# Charlotte Department of Transportation

## Memorandum

**Subject:** Rezoning Petition 08-130: Located on the northwest corner of North Davidson Street and Charles Avenue  
(revised 9/12/08)

PROPOSED SITE PLAN  
SCALE: 1/16" = 1'-0"

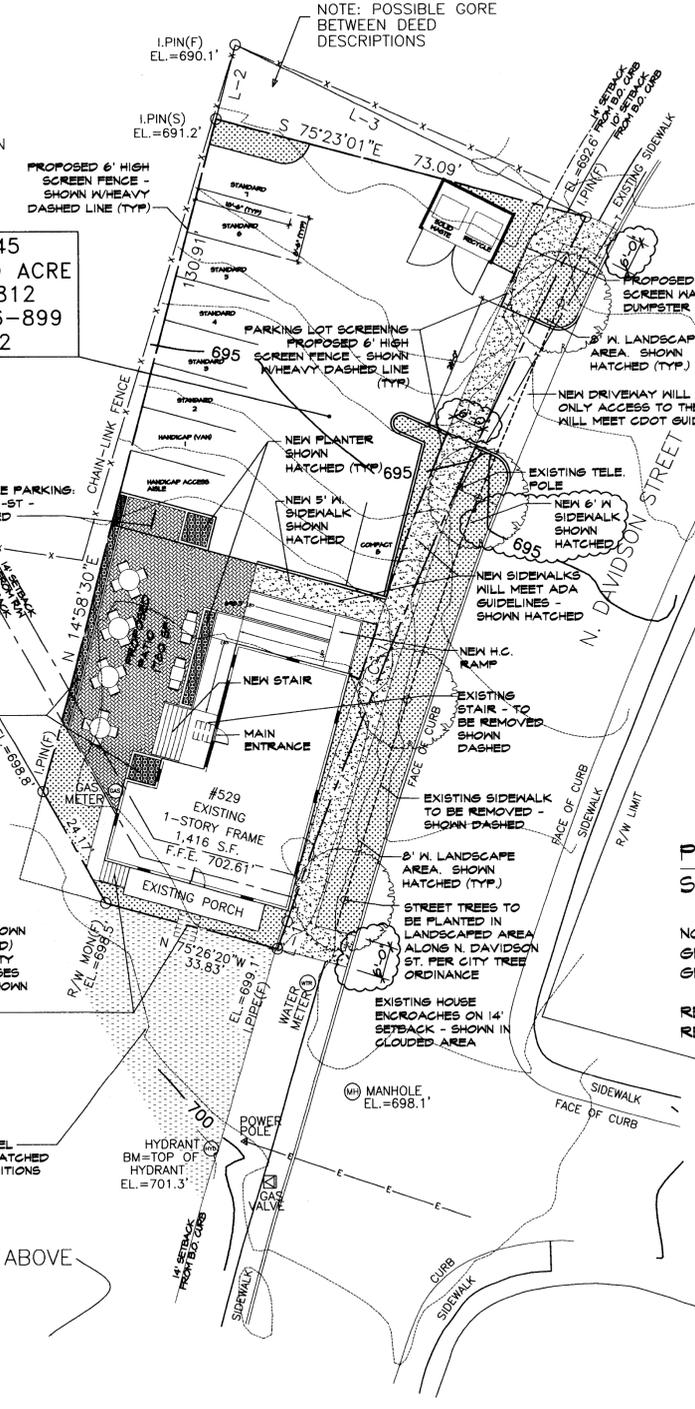
1. The optional request to keep the gravel parking lot is not supported. The site is constrained and at a critical point in a curve where sight distance is an issue, so paved parking provides the optimal maneuvering surface. This note should be removed from the site plan. (*Previous review comment – 2<sup>nd</sup>*)
